Consultation Report

Appendix 8: Consultation Responses and Continuing Consultation

Thurrock Flexible Generation Plant

Application document number A5.1.8

Figure 1.1: Development zones.

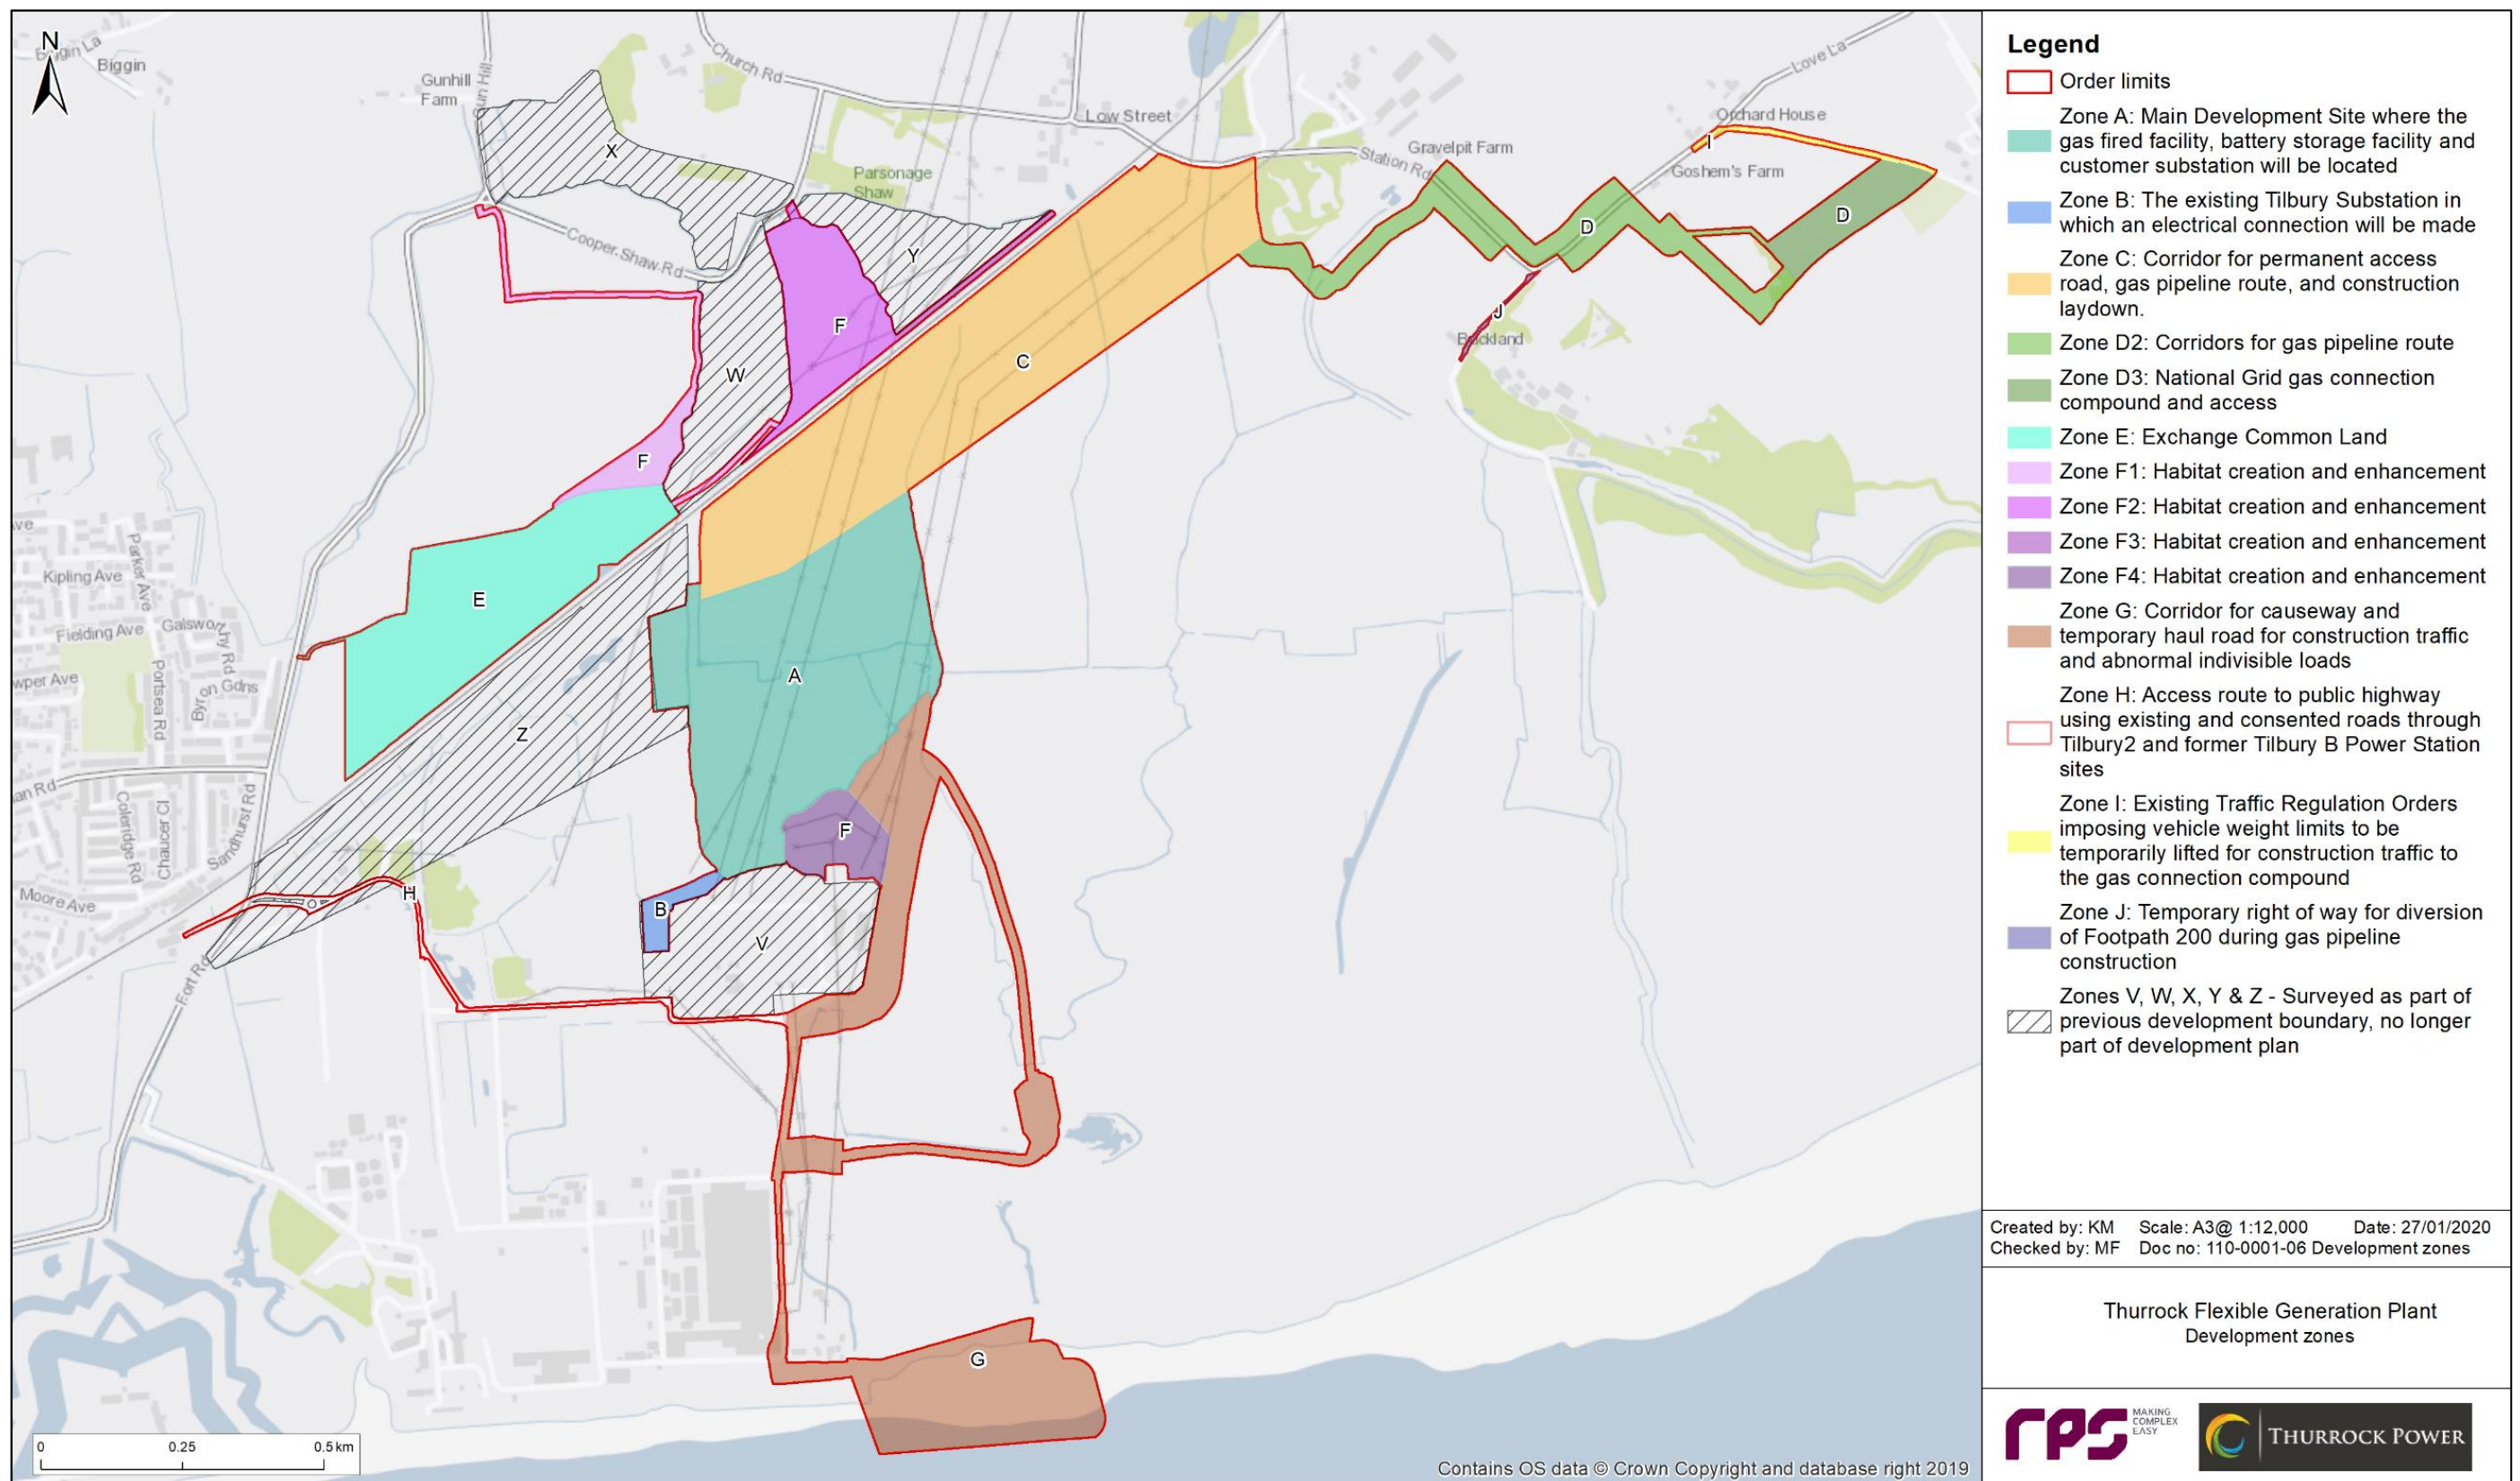
Unfortunately the desktop study described in Appendix 9.1 of the Ecological Desk Study and Surveys document completely fails to fulfil its purpose as a desk study. Paragraph 2.1.1 states that Ecological records within a 2 km radius of Zones A-J (as shown on Figure 1.1) were requested from the Essex Wildlife Trust Biological Records Centre and the Kent and Medway Biological Records Centre. However the Essex Biodiversity Validation Checklist, supported by Natural England's local Land Use Operations team and endorsed by the Essex Biodiversity Project, makes clear that the Essex Field Club datasearch system is the main source of species records in Essex. Desk study species data shown in Appendix 9.1 is therefore completely inadequate, not fit-for-purpose and fails to fulfil any useful purpose.
